From: Paul Cann <Paul.Cann@arun.gov.uk>
Sent: 26 May 2022 13:30
To: Planning.Responses <Planning.Responses@arun.gov.uk>
Subject: RE: Planning Consultation on: F/5/22/DOC

Application No: F/5/22/DOC
Registered: 24th May 2022
Site Address: Wicks Farm Ford Lane Ford BN18 0DF
Description of Works: Approval of details reserved by condition imposed under F/7/21/PL relating to conditions 3-surface water drainage scheme, 4-discharge of flows to watercourses, 5-maintenance and management of surface water drainage, 6-landscape screening scheme, 7-contamination and 9-ecological enhancements.

From: Paul Cann
Sent: 26 May 2022 13:22
To: Stuart Magowan
Cc: John Hall; David Moore; CEP | Reception; Anita Gardner
Subject: RE: 23482 Wick Farm East - F/7/21/PL Planning Conditions 3 and 5

Note: The use of precast concrete chamber units to E2.29 with 150 mm GEN3 in-situ concrete complying with E4.1 and BRE Special Digest 1 in place of brickwork construction is permitted.

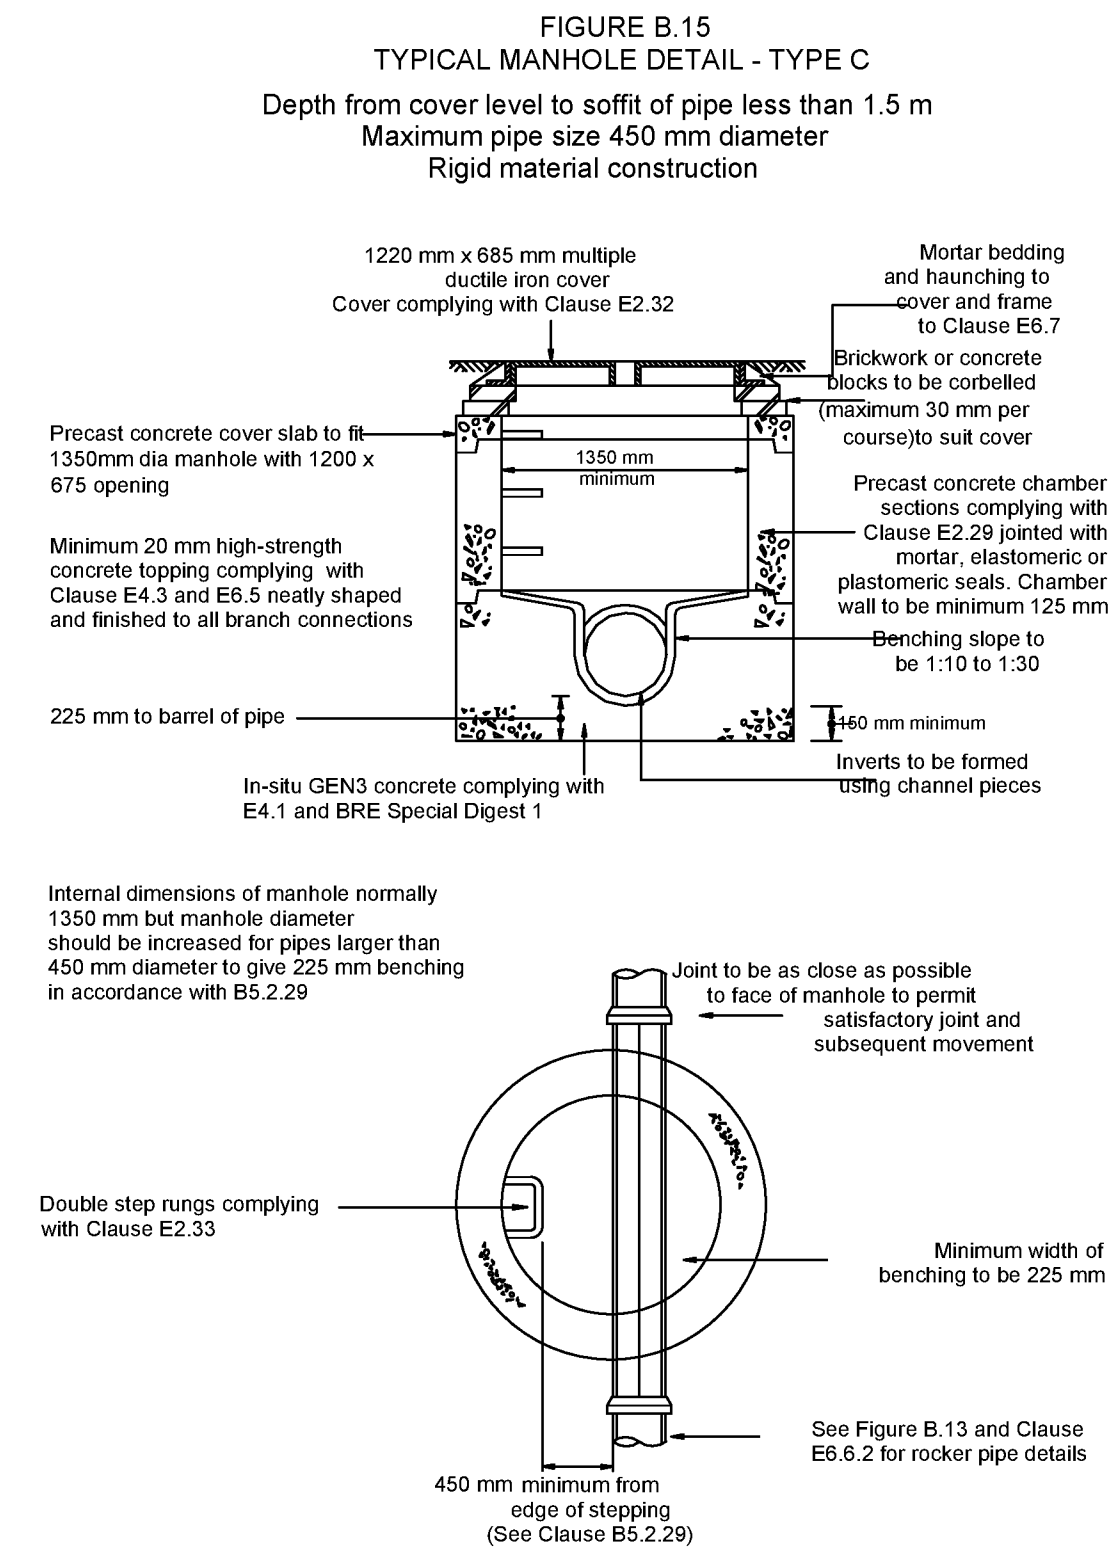
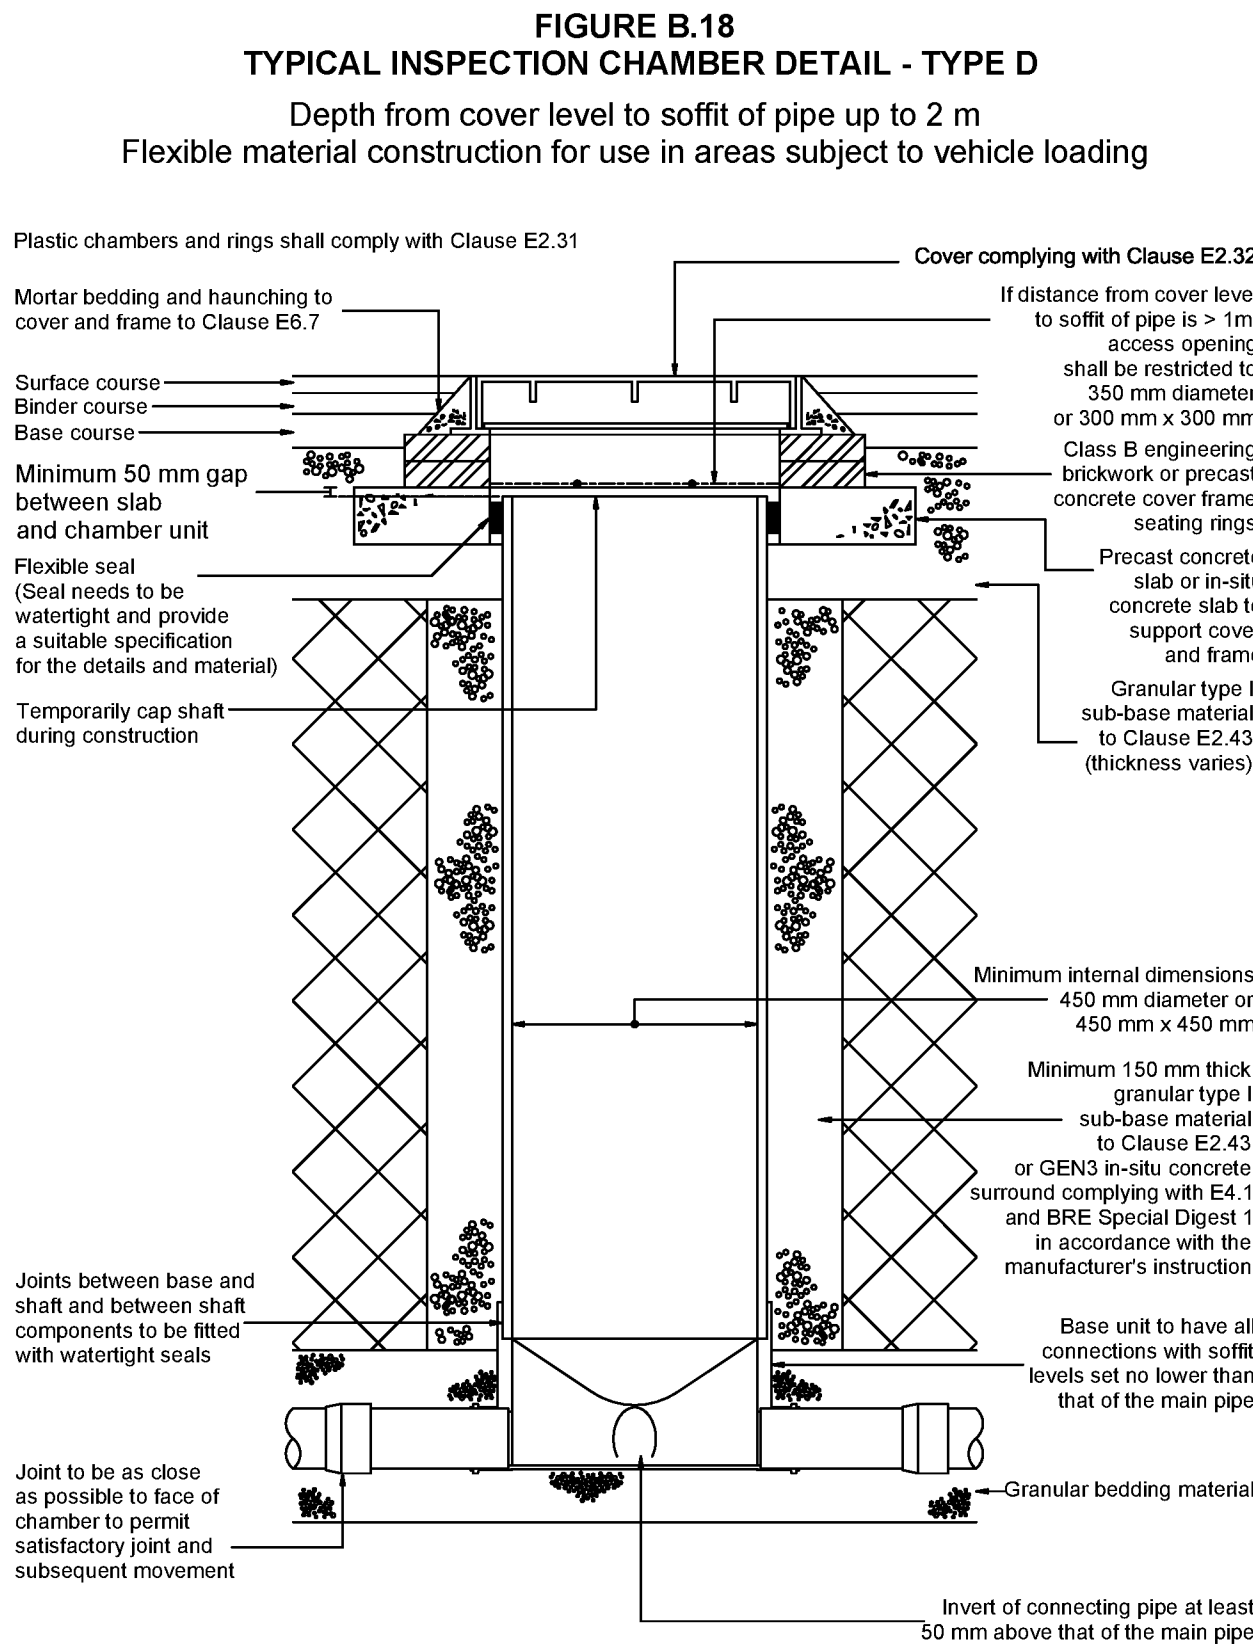
10. **Type C manhole – indicate PPC cover slab to suit.** Clearly indicate the PCC rings and 150mm concrete surround. The Type C manhole detail provided is the standard adoptable detail from Sewerage Sector

Guidance with PCC cover slab. We are not proposing a 150mm concrete surround for these private manholes just noticed the chamber sections are 125mm thick, so greater than standard, so ok.

Hydrobrake HB02 SHE-0084-2600-0503-2600 manhole dimensions	
Ref	Dimension mm
'A'	530
'B'	90
'C'	675
'D'	275
'E'	180
'F'	325

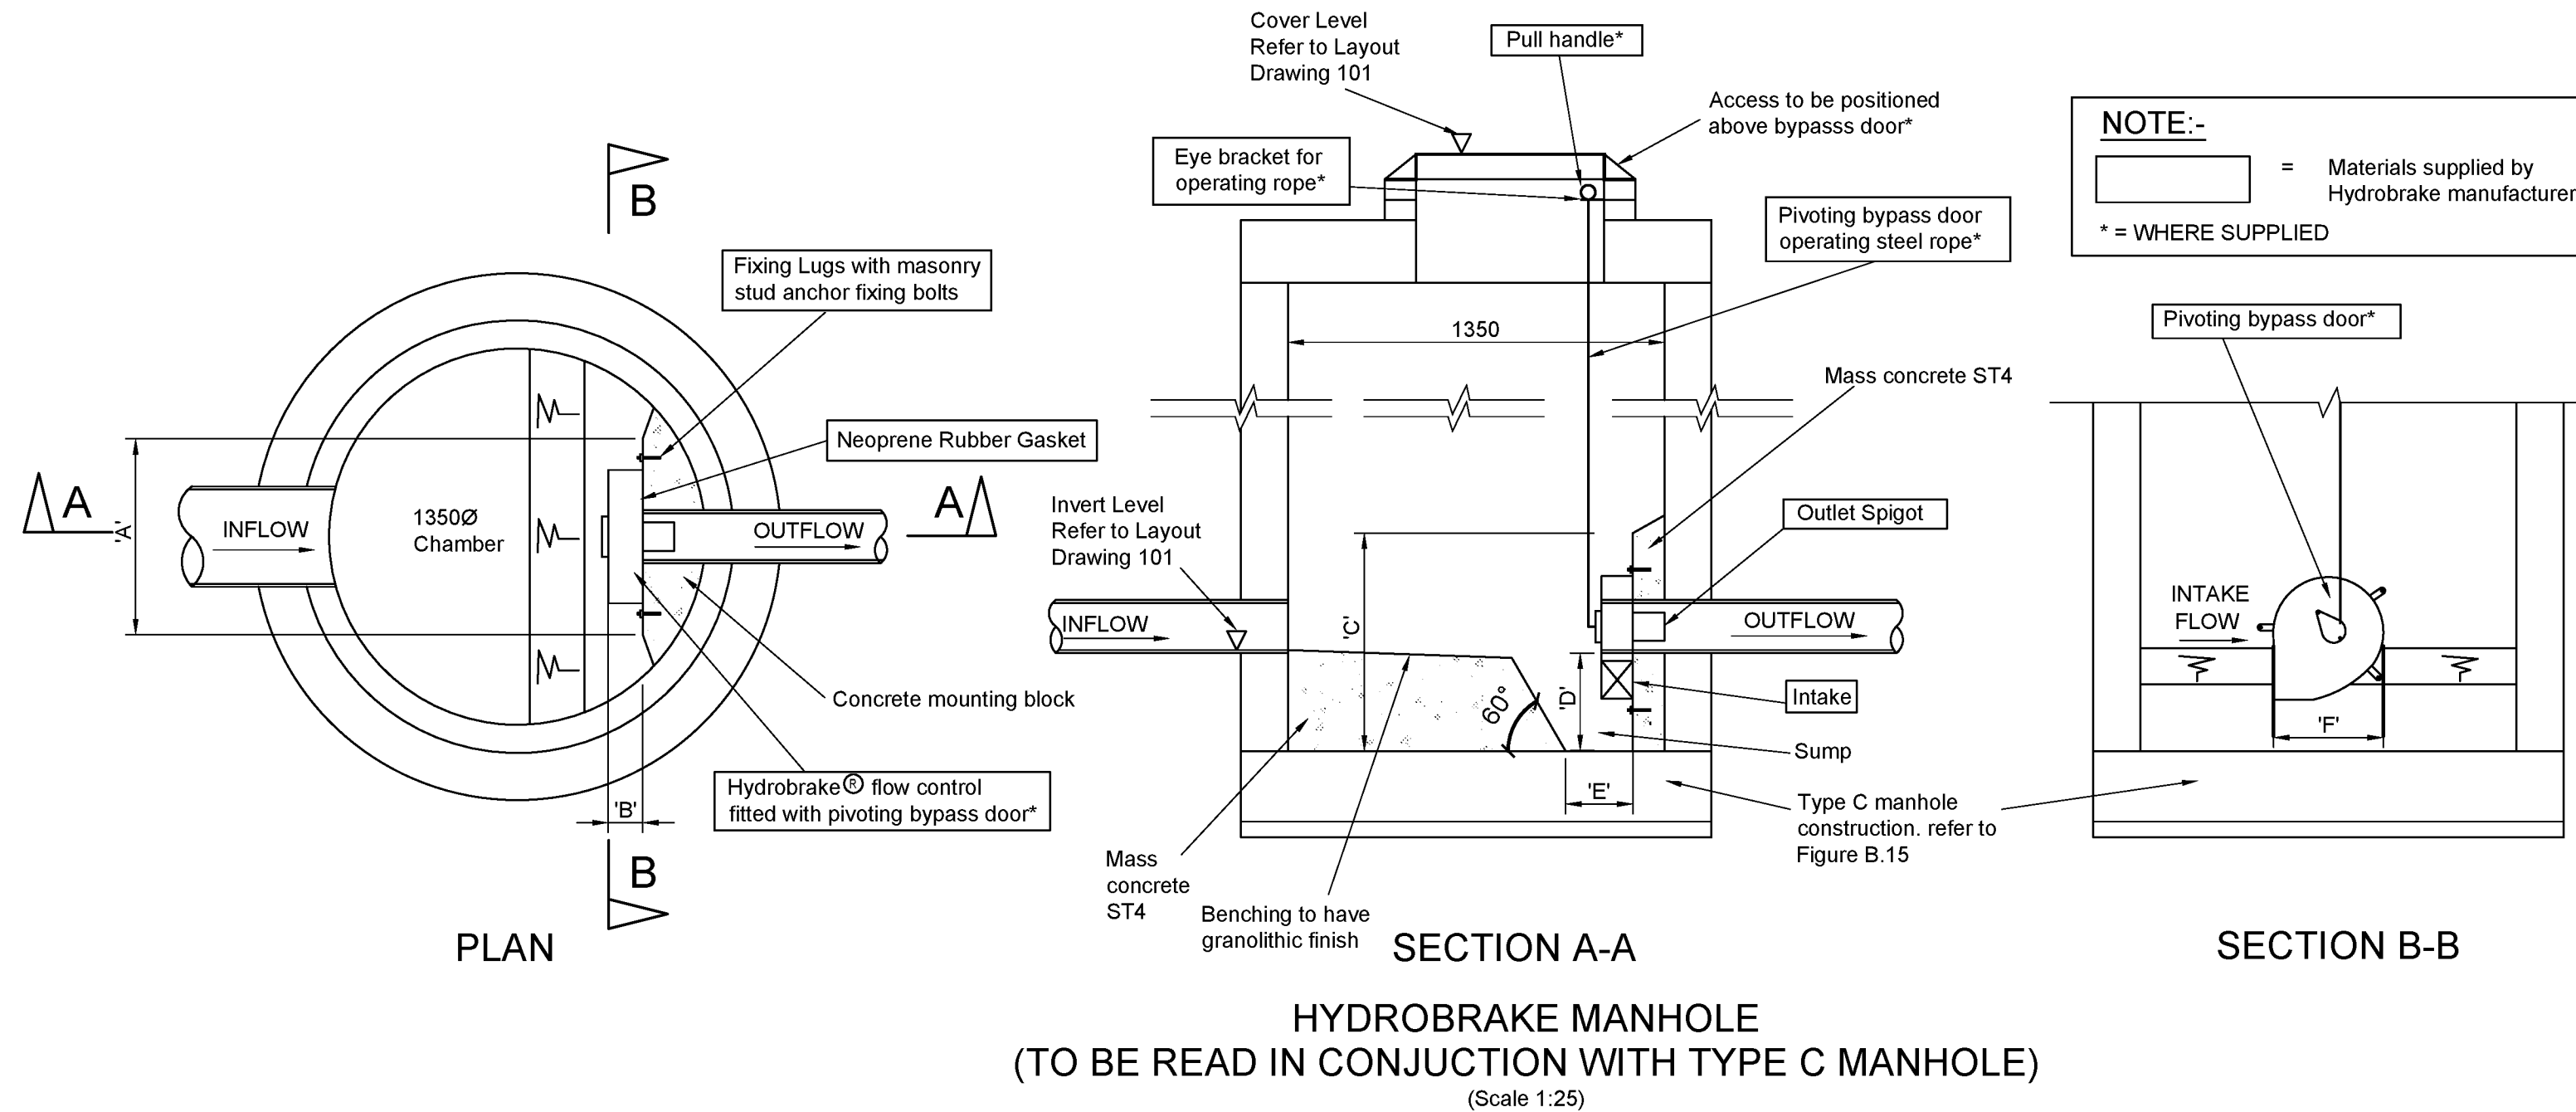
11. **Hydrobrake manholes – add note ‘to be read in conjunction with type C manhole detail’.** Manhole schedule specifies 1350mm diameter chamber but 1500mm on construction details. The dimension tables for each chamber need to be completed. Specify hydrobrake models. Noted, 1350 chamber required as schedule, construction detail adjusted on drawing 501A, copy attached. Data sheet only supplied for one of the hydrobrake’s. Also, add model numbers to drawings. Specify the cover slab details as this is not detailed on the type C manhole. We have attached both Hydrobrake Data sheets for the SHE0076-2000-0375-2000 and the SHE 0084-2600-0503-2600 and confirm the cover slab detail has been updated on the Type C manhole detail on drawing 501 B, copy attached, and notes a 1350mm diameter precast concrete cover slab with 1200 x 675 opening.

12. Hydrobrake manholes – add note 'to be read in conjunction with type C manhole detail'. Manhole schedule specifies 1350mm diameter chamber but 1500mm on construction details. The dimension tables for each chamber need to be completed. Specify hydrobrake models.

ELEVATION OF HEADWALL
OUTFALL TO SIDE OF EXISTING DITCH
(Scale 1:20)

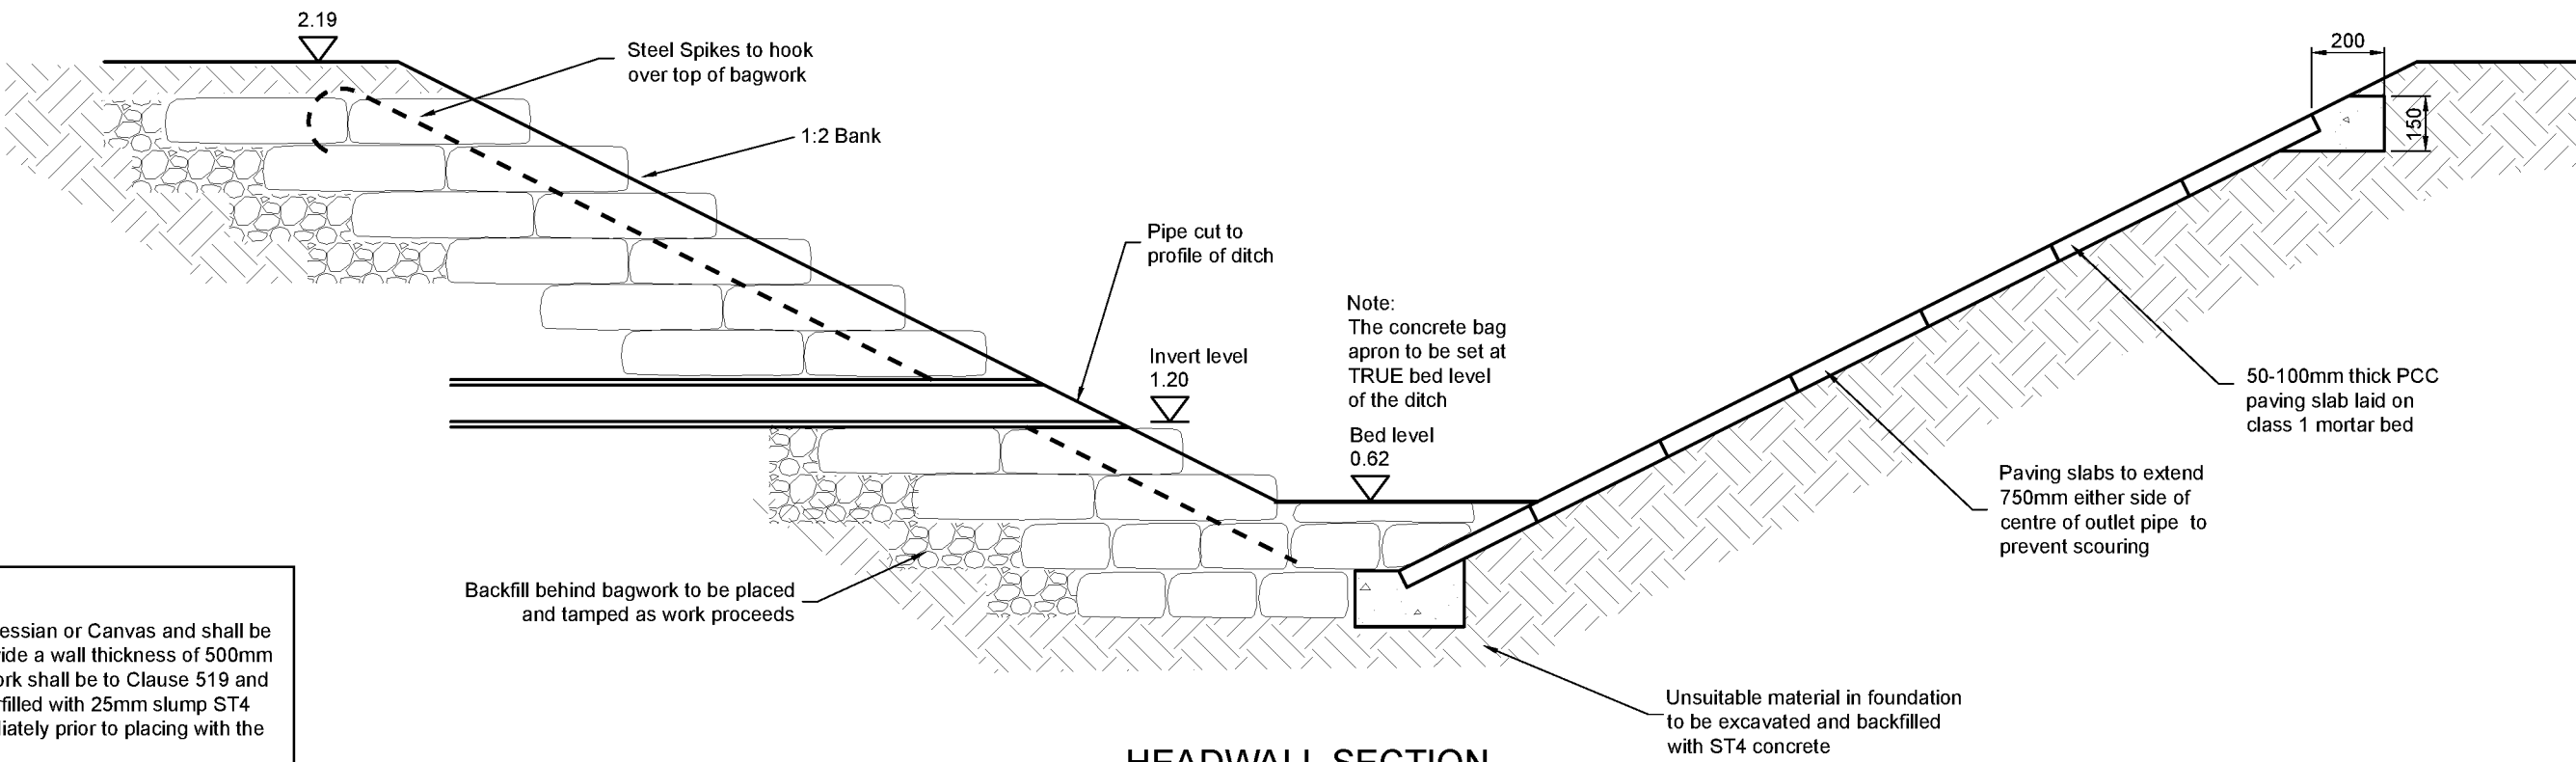
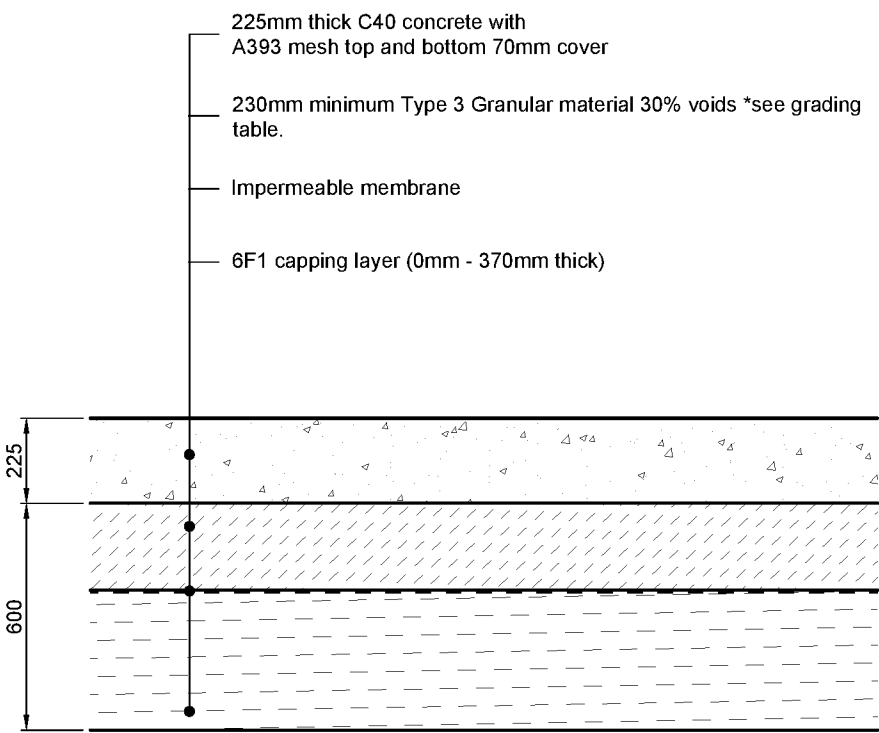
15. **Reservoir flood storage note for 1/100+40% event on plan – should 4.243 be 4.143 based upon the calcs?**
Yes, typo adjusted ok
16. **Headwall – Show pipe cut back so not encroaching into ditch profile. Bagwork apron to be set at true bed level of ditch (to be determined/agreed). 100mm freeboard needs increasing. Construction details refer to a swale as opposed to a ditch – please adjust.** Detailed adjusted on drawing 502A Based upon the levels you have provided, there is around 500mm difference between pipe invert and existing ditch bed, if BL represents the ditch base level. Please alter the construction detail to reflect this. A note should also be added to say that the concrete bag apron to be set at TRUE bed level of the ditch. Noted and drawing 502 B updated

15. Provide reservoir construction details.
16. Reservoir flood storage note for 1/100+40% event on plan – should 4.243 be 4.143 based upon the calcs?
17. Headwall – Show pipe cut back so not encroaching into ditch profile. Bagwork apron to be set at true bed level of ditch (to be determined/agreed). 100mm freeboard needs increasing. Construction details refer to a swale as opposed to a ditch – please adjust.
